**Draft Development Consent Order Hearing 1 Session 1
Transfer of Assets (43.30 in the transcript)**

Norfolk County Council
Identification No: TR010038
Registration identification number: 20028389

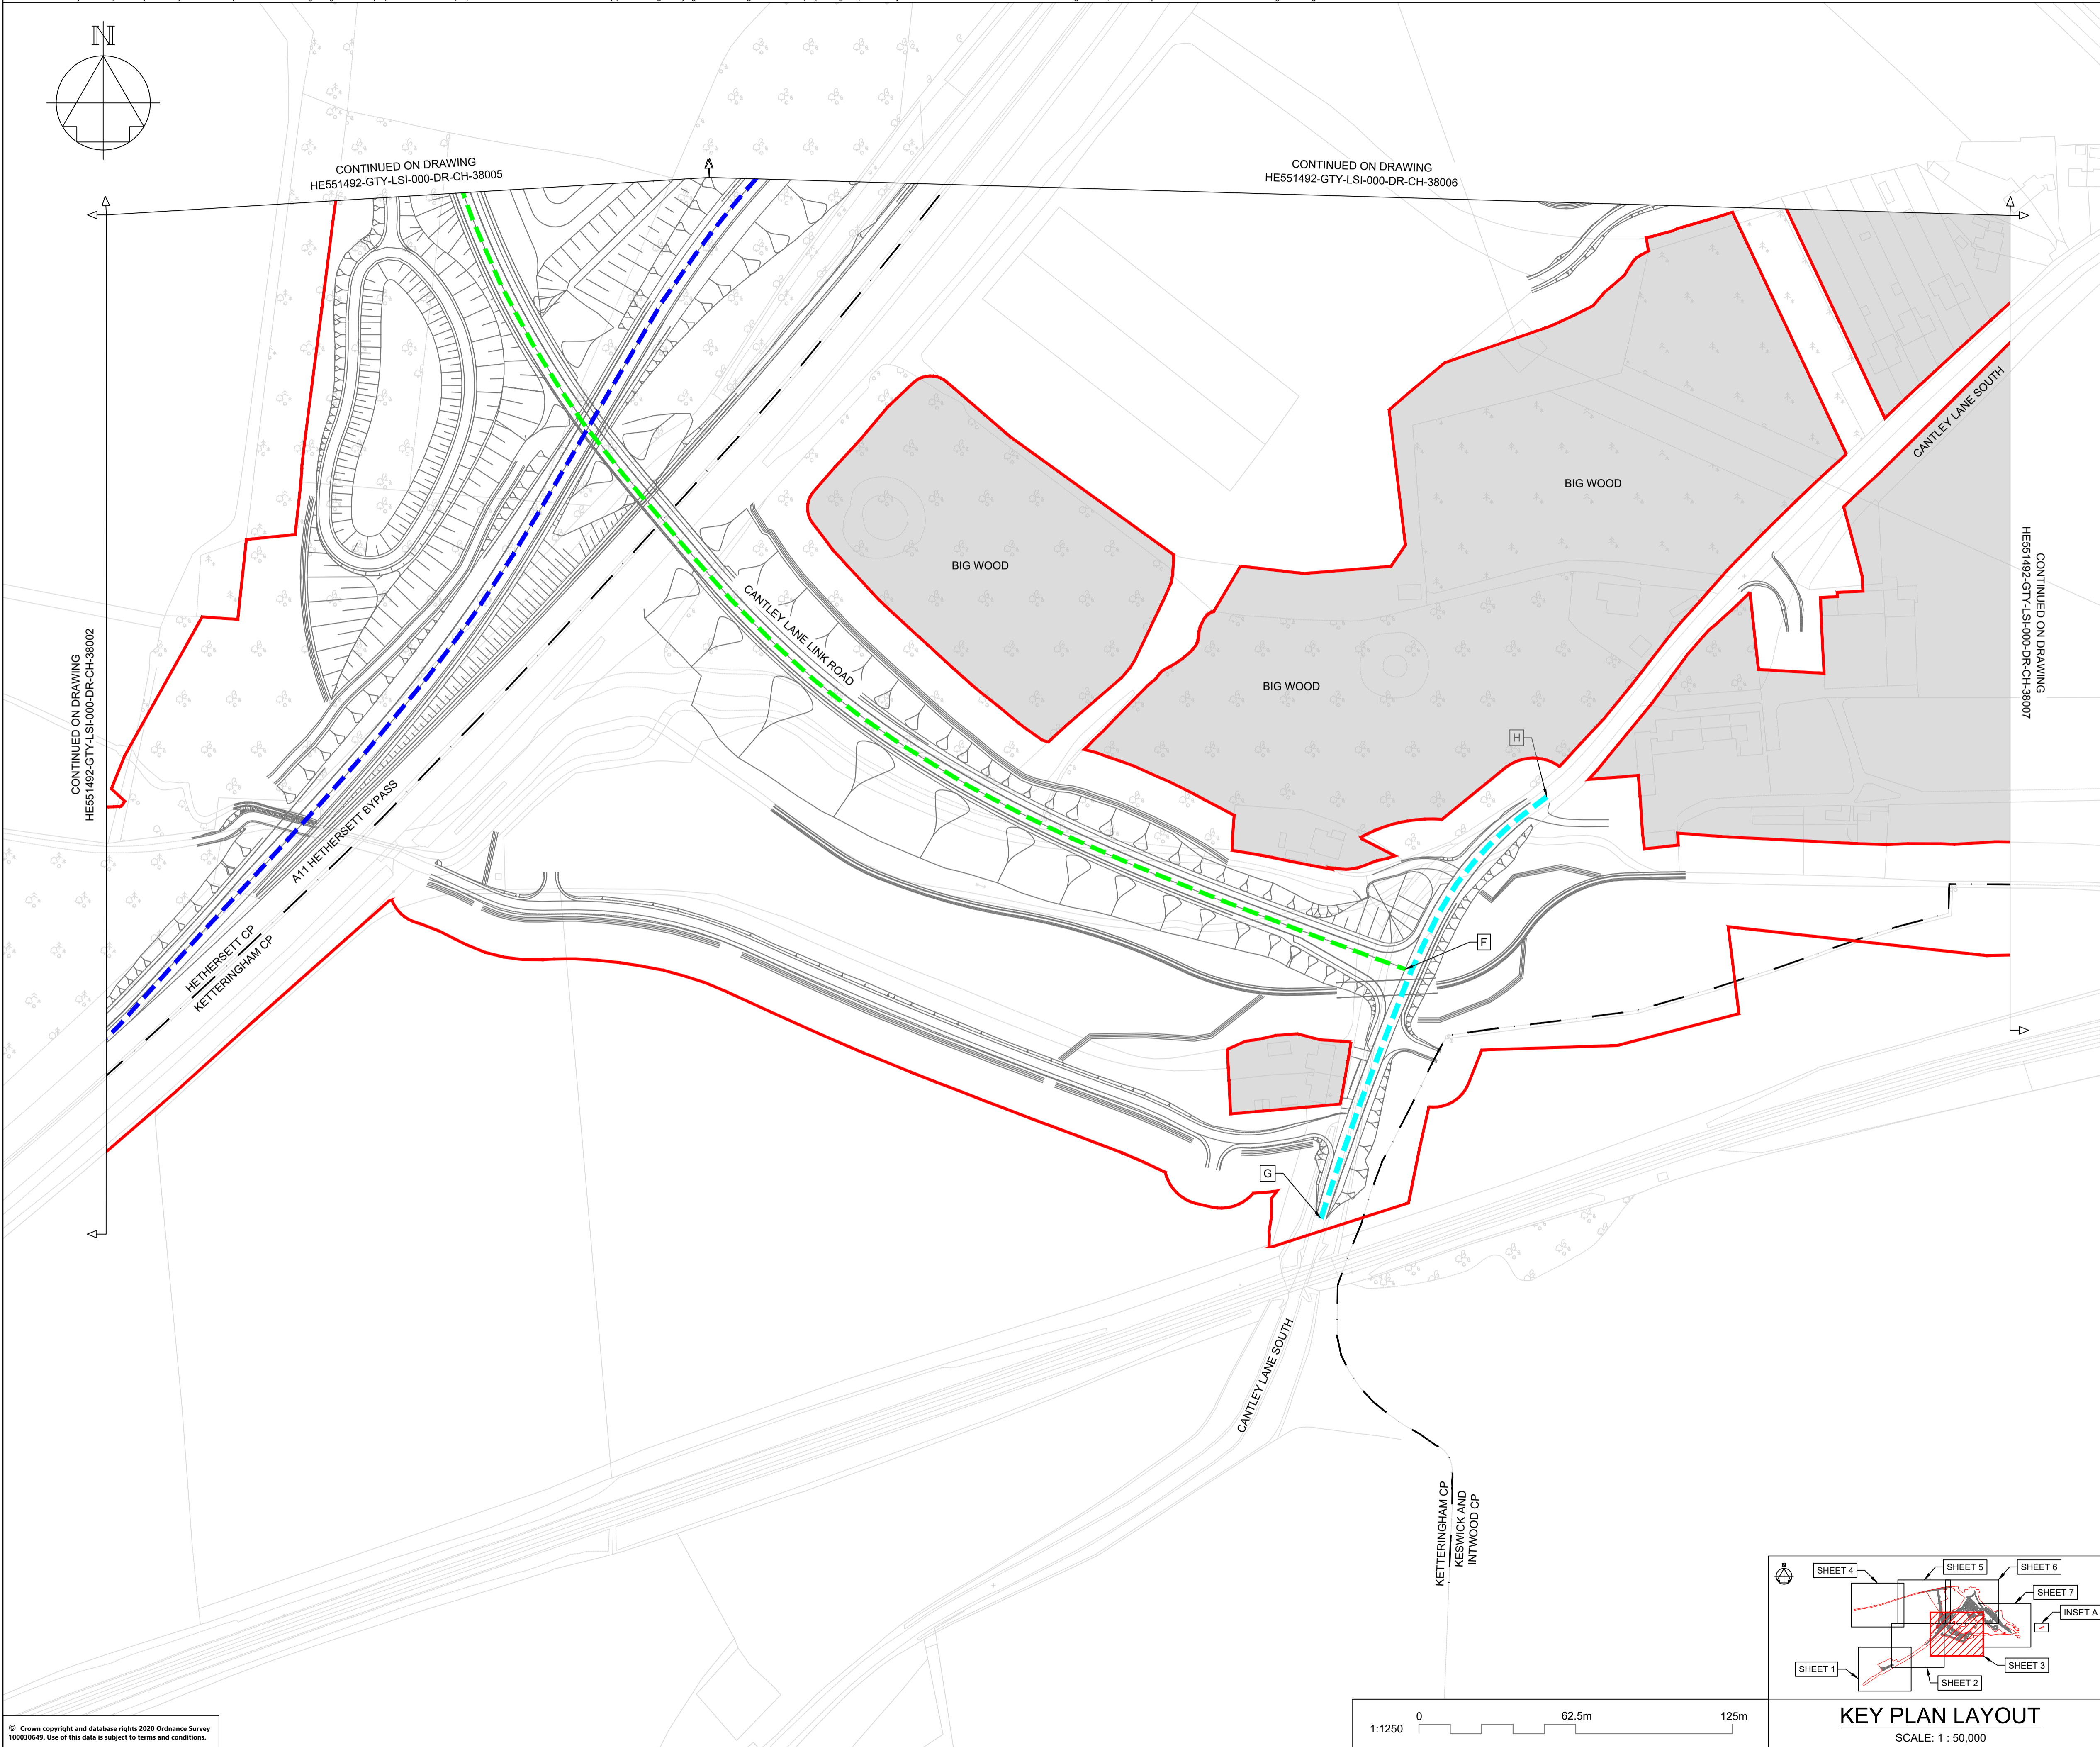
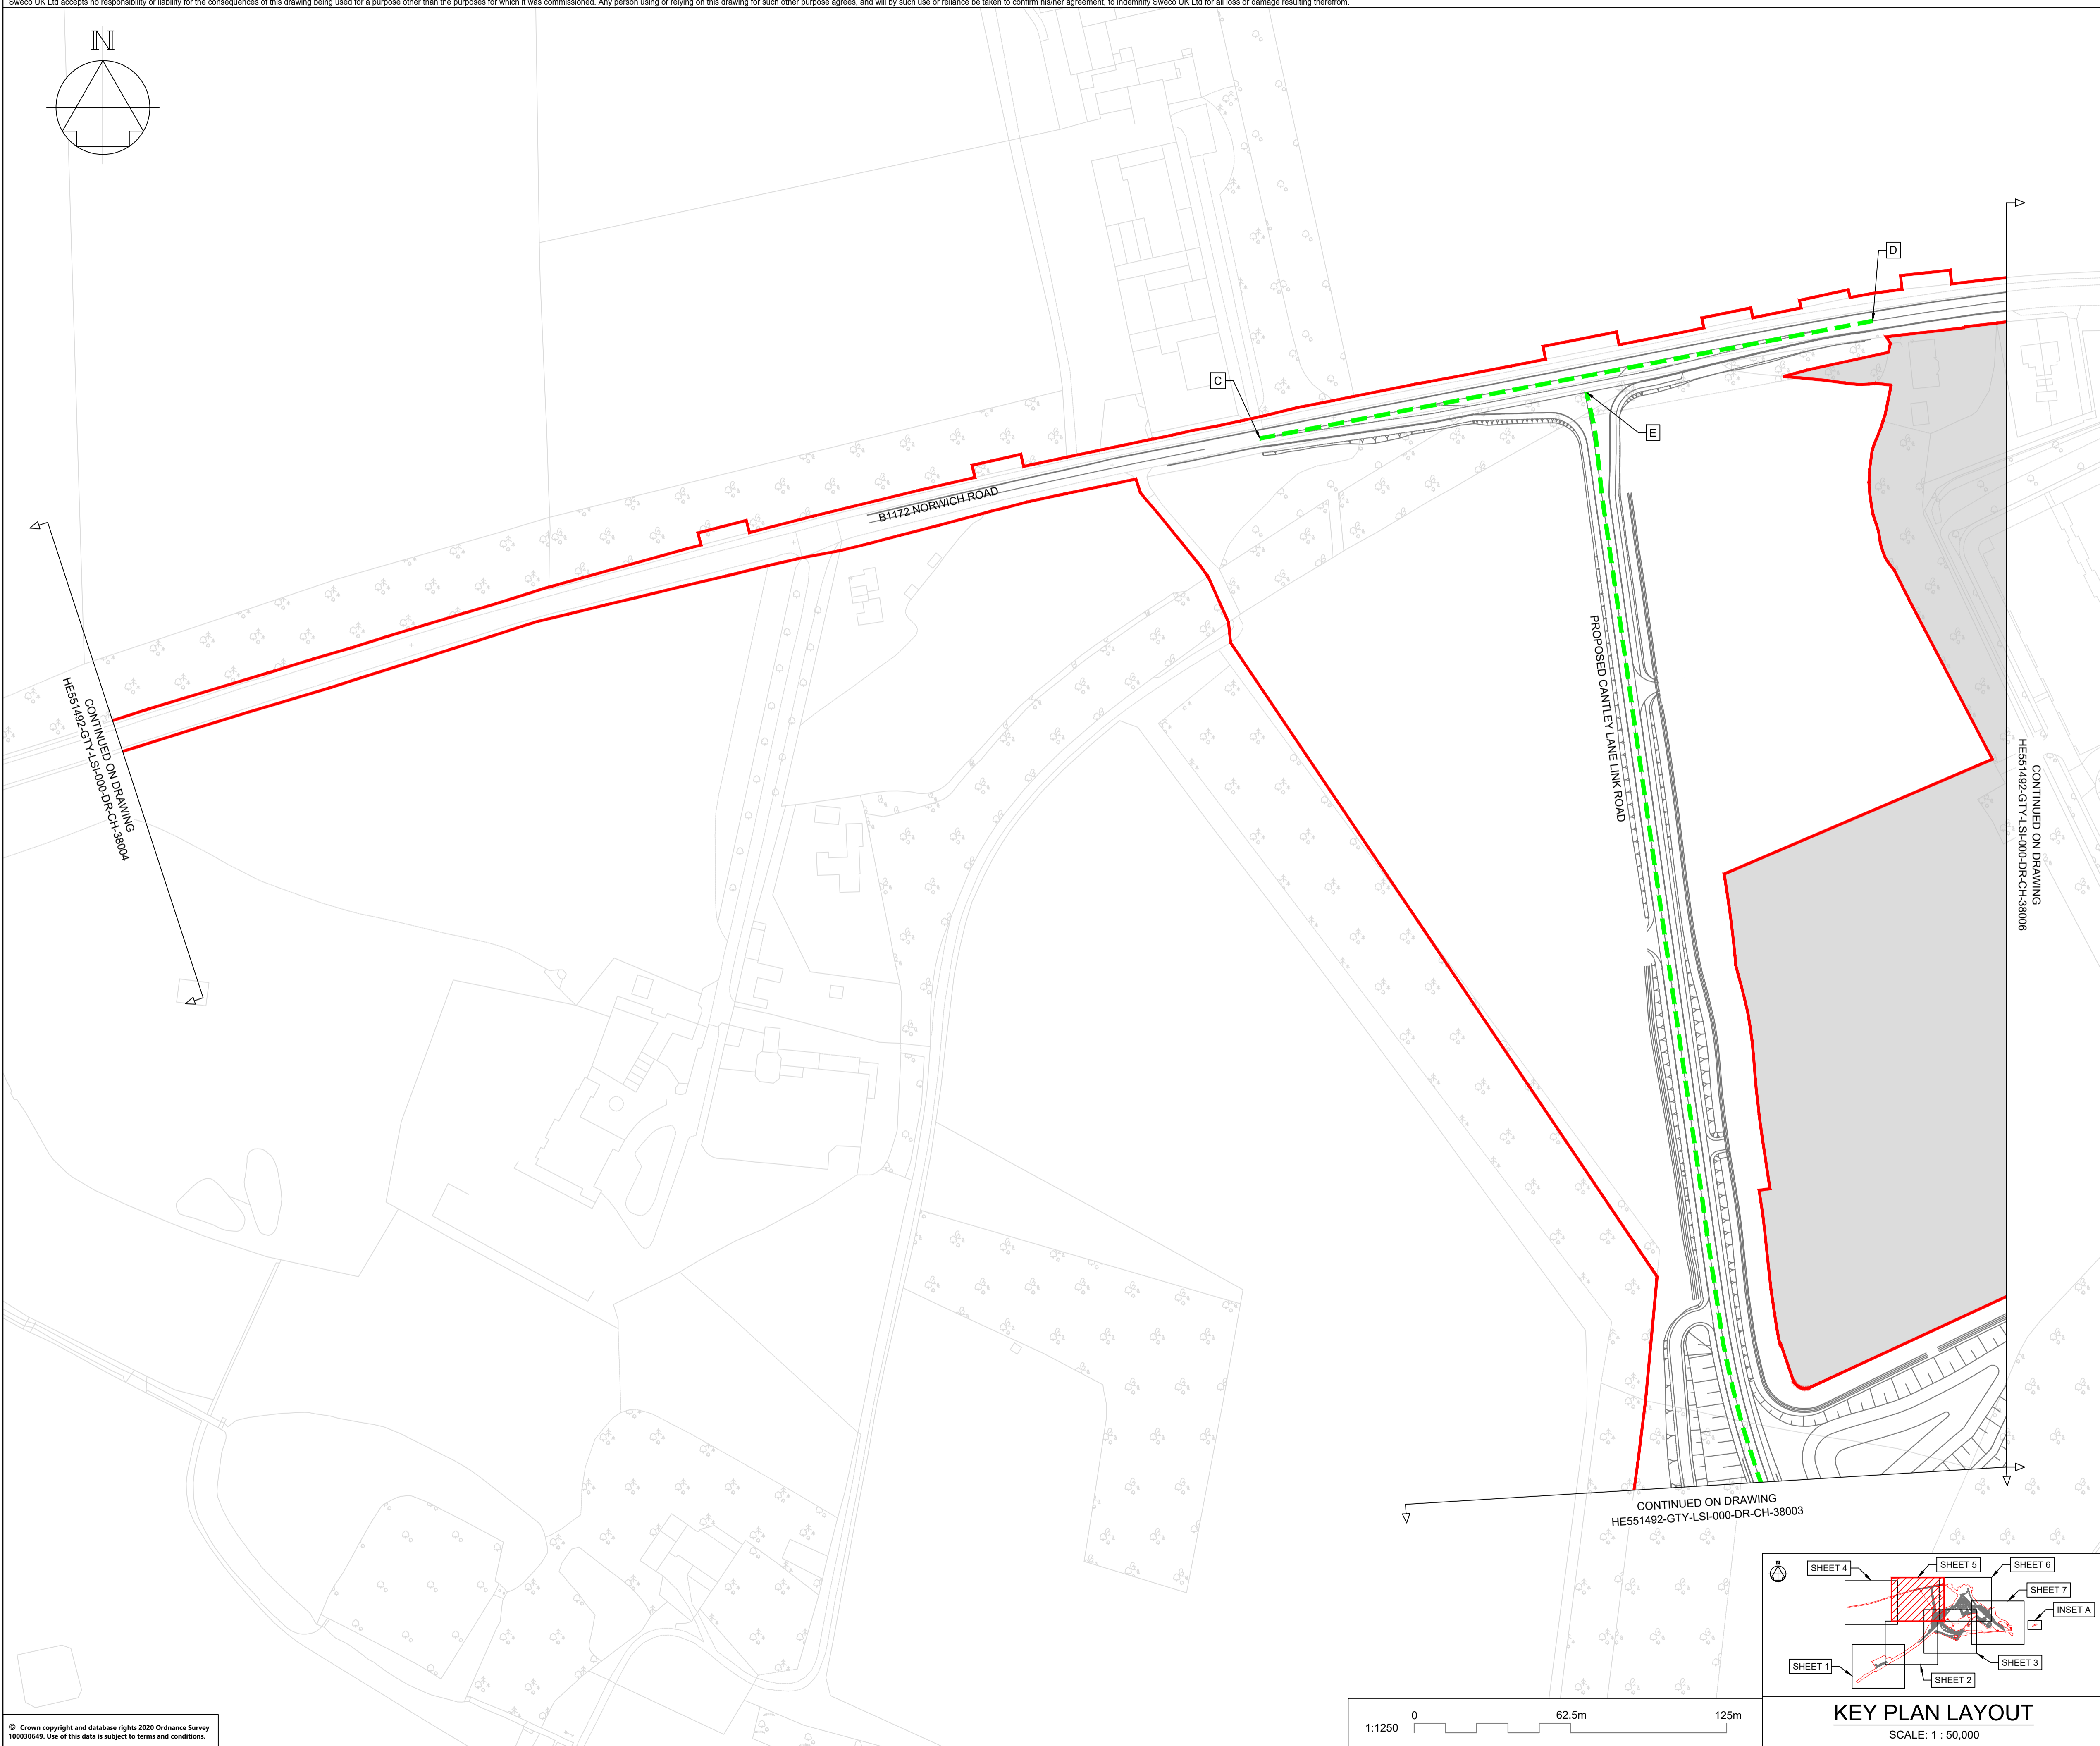
On the proposed classification of the new link from Cantley Lane to the B1172 as a Class B road (1.01.12 in the transcript)

The A11 and the A47 are the main roads within the area, and much of the rest of the network comprises minor roads. We have had concern expressed to us by some of the local residents and their representatives (parish councils) that the new link road would draw traffic from the south east up through Cantley Lane and the new link road, although we don't expect that to be a significant impact of the scheme.

However, the classification of the new link road as a B road would indicate to motorists, and also to things like Sat Nav systems, that it is part of a more major road network and could lead to its use by additional traffic.

The county council does not support classification of the new link road as a B class road.

The county council welcomes the applicant's statement (in the Hearings) that it will be led by the county council in respect of the classification of the new link road. This will be reflected in the Statement of Common Ground.
